Our Ref: EN010122

Application by Oaklands Farm Solar Limited (“the Applicant”) for a non- material change (“NMC”) to the Oaklands Farm Solar Park Order 2025 as corrected by the Oaklands Farm Solar Park (Correction) Order 2025

REQUEST FOR INFORMATION

Document Ref: EN010122/NMC/2.3

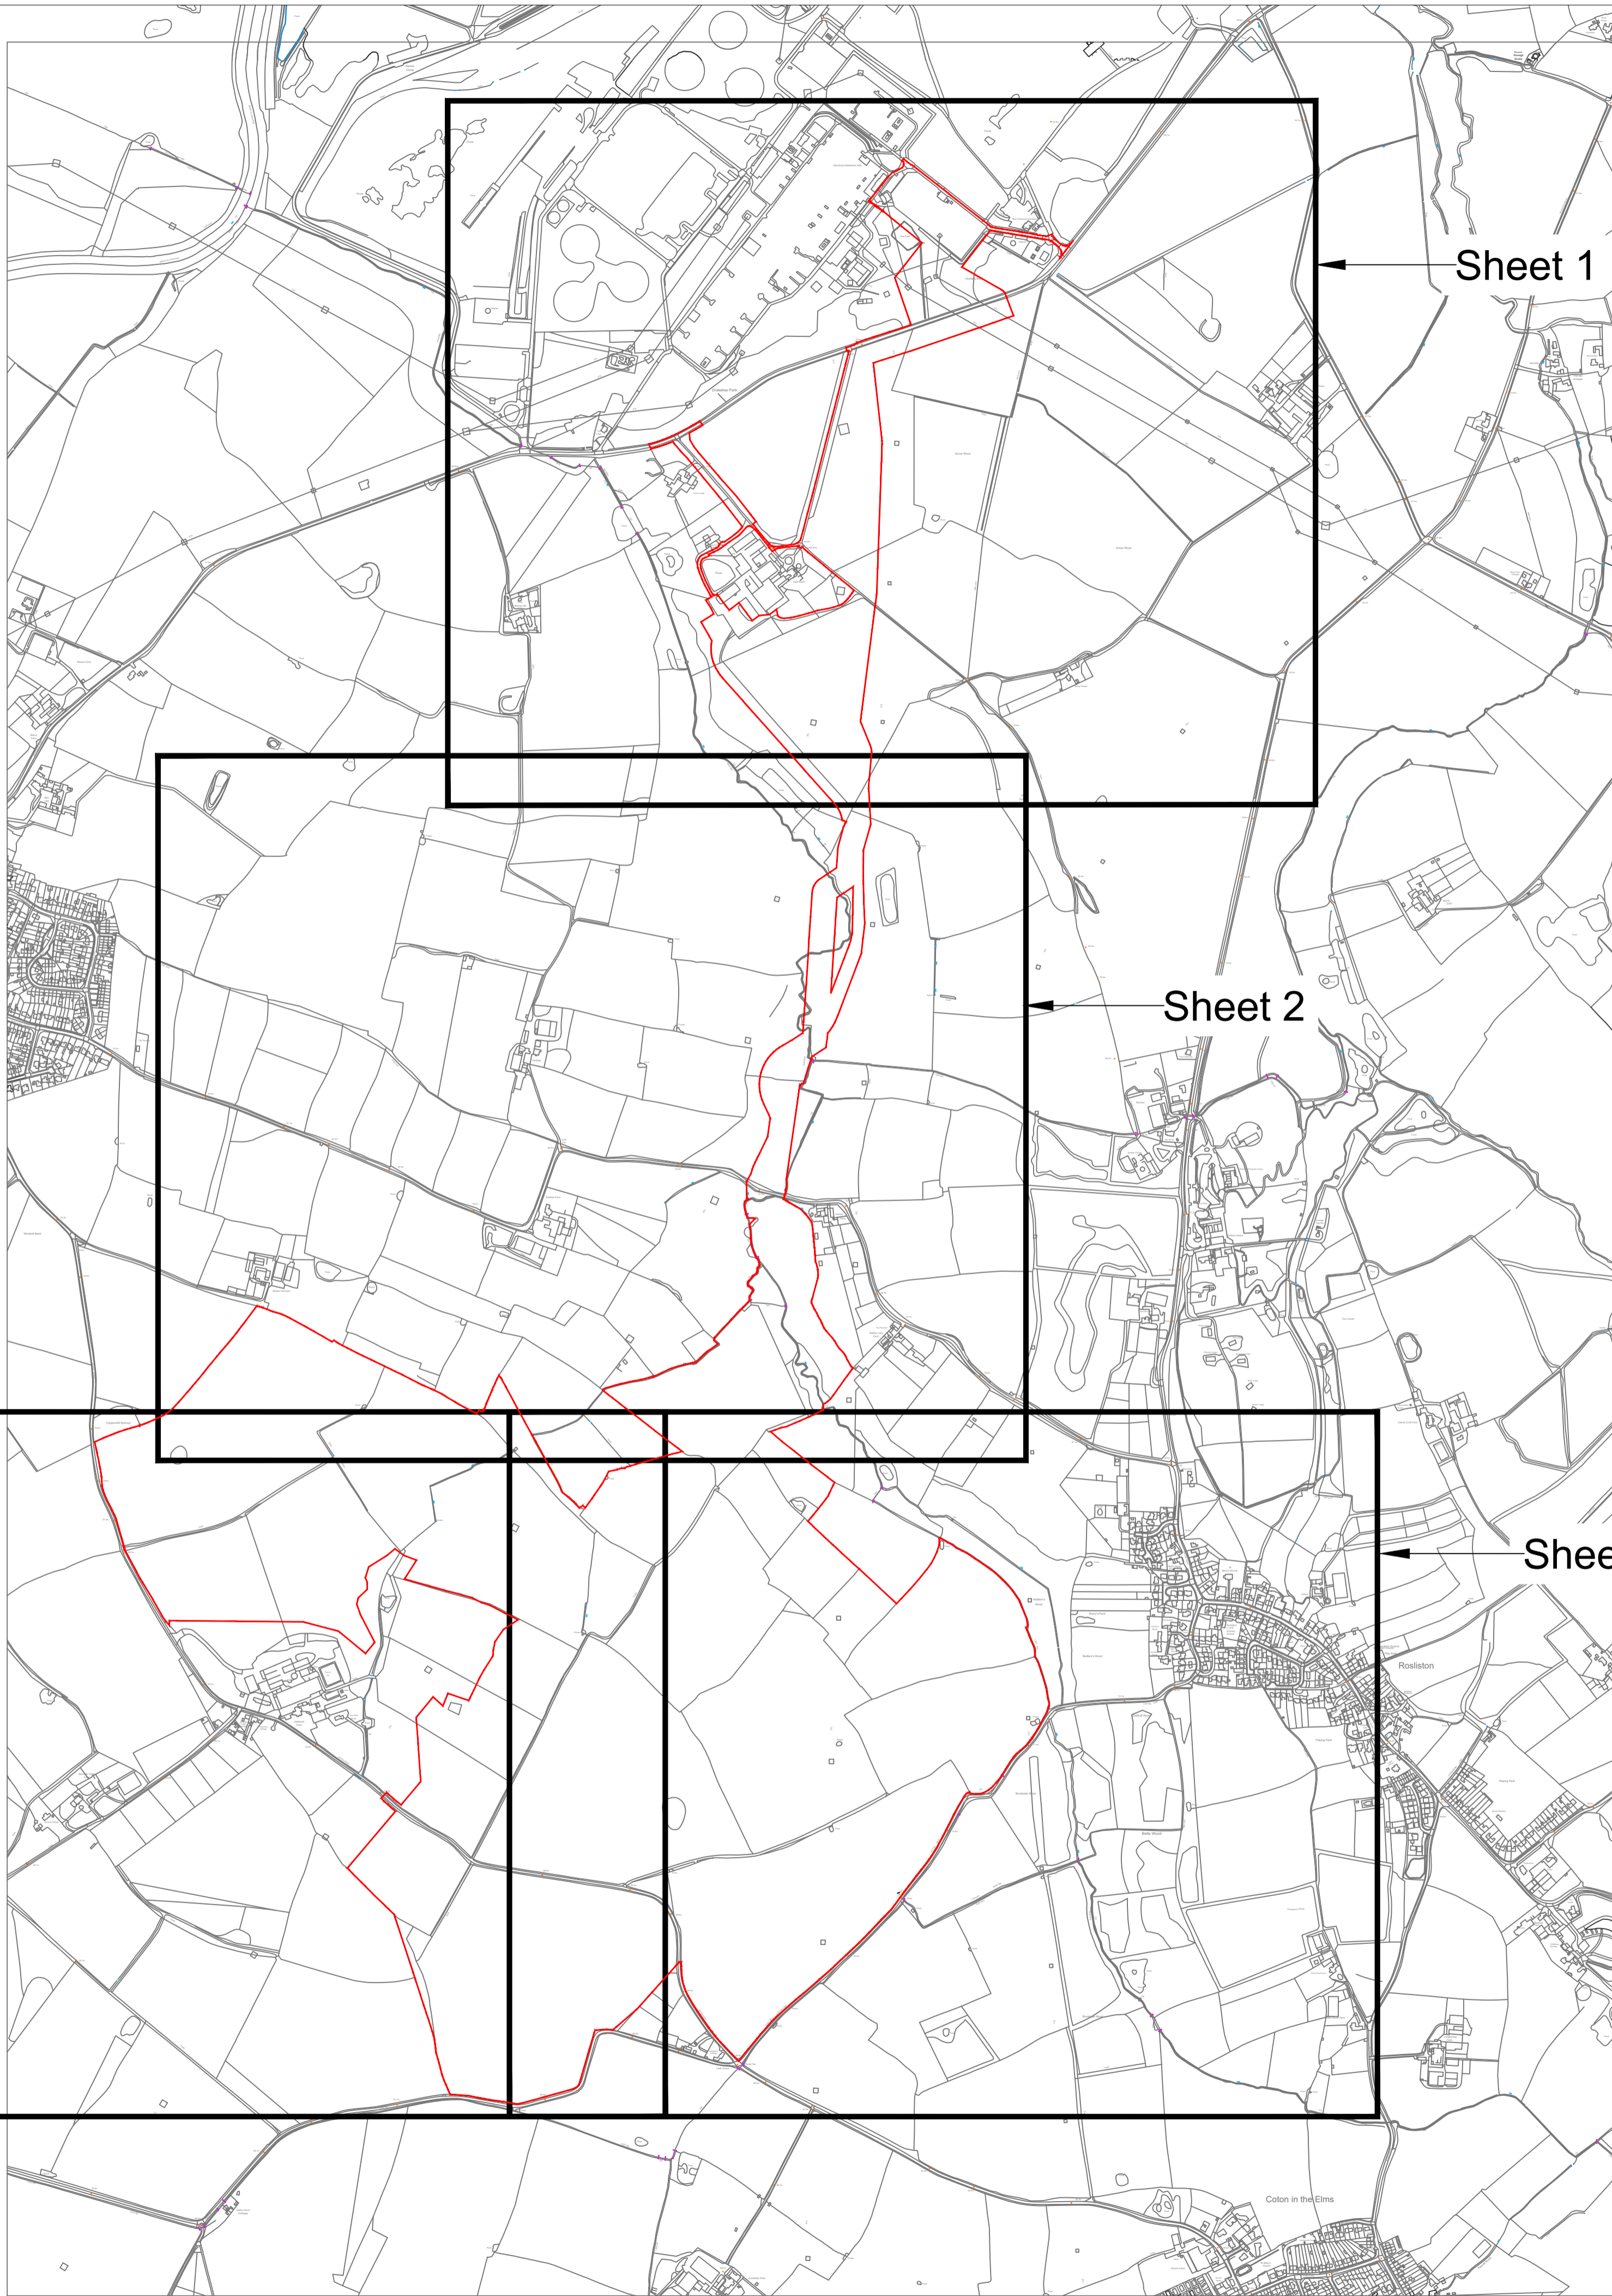
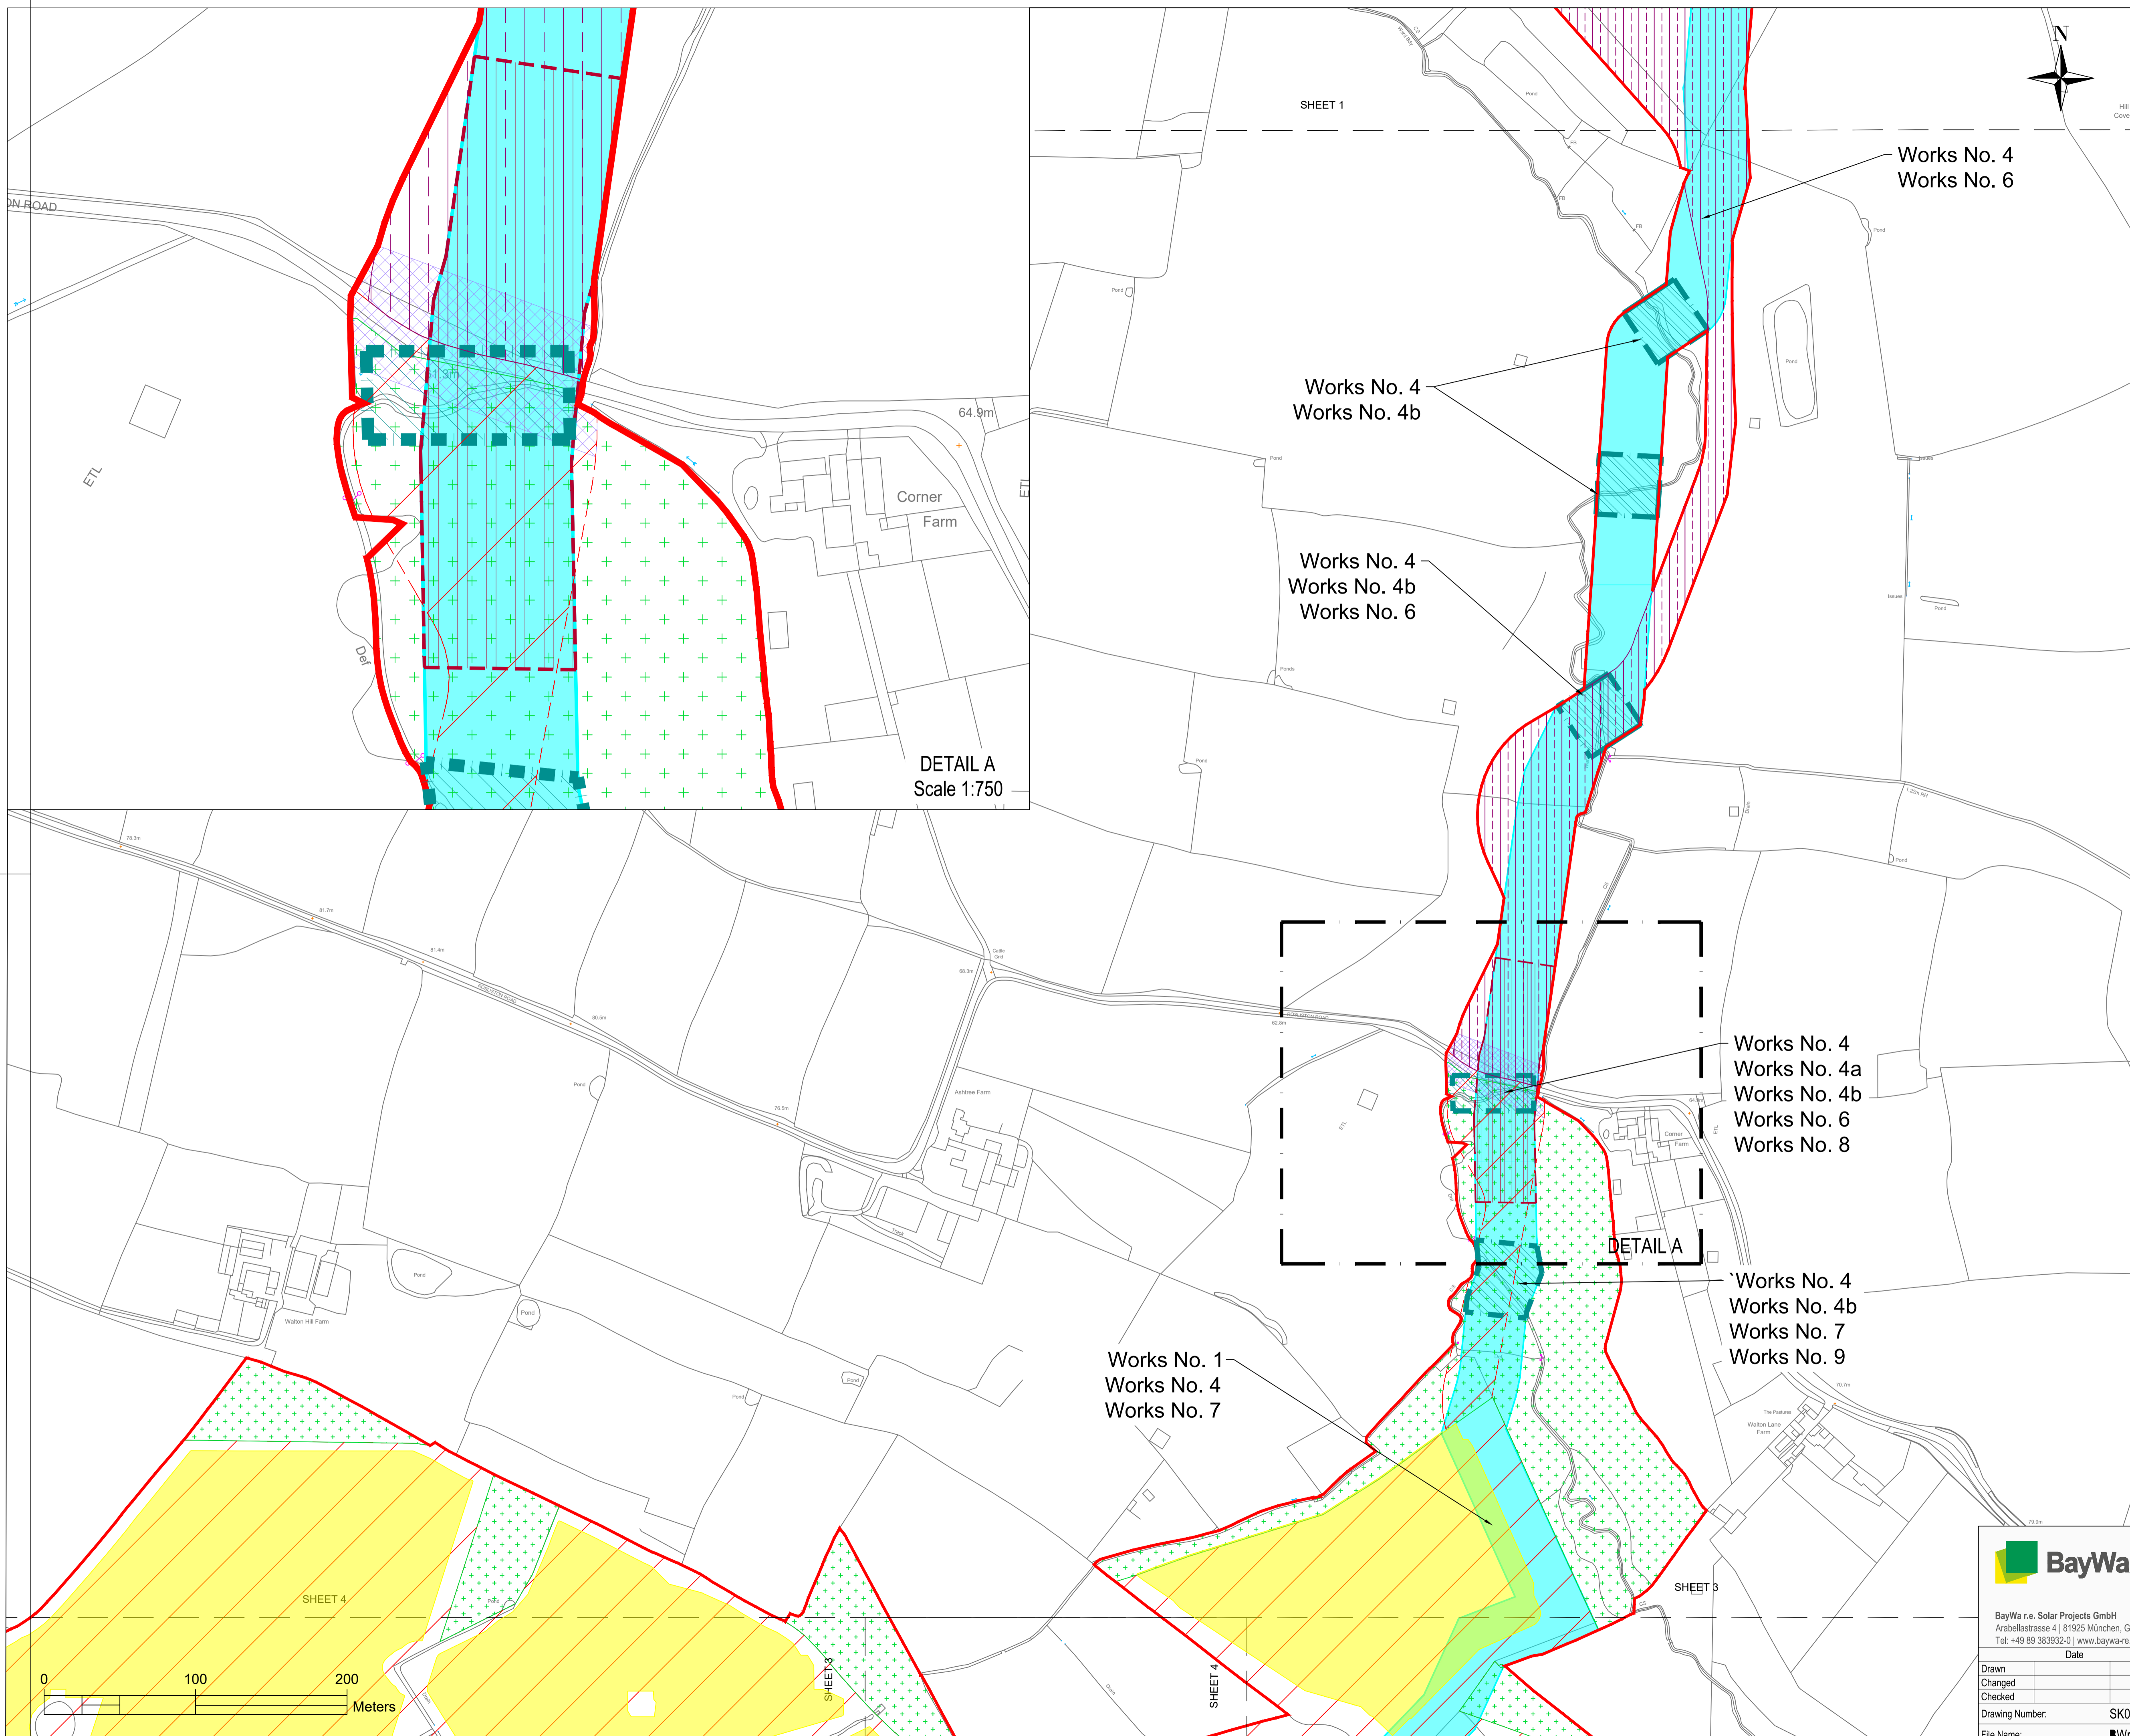
1. The Secretary of State has considered the Application documents, the responses received to the Applicant’s consultation and the reply from the Applicant to the Environment Agency’s consultation response.
2. The Secretary of State notes the revised Works Plan (EN010122/NMC/2.3), revised Environmental Statement - Chapter 4 Project Description (EN010122/D6/6.1) and the revised Appendix I of the Design Statement (EN010122/NMC/7.2) submitted with the Application. There are matters on which the Secretary of State would be grateful if the Applicant and the Environment Agency could provide updates or information as appropriate regarding the changes being proposed and their likely environmental effects.

9. **The Applicant** is requested to comment on whether the proposed amendment of the solar array layout will impact the ability to adhere to the existing 5m hedgerow and the 15m tree root protection zone buffers.
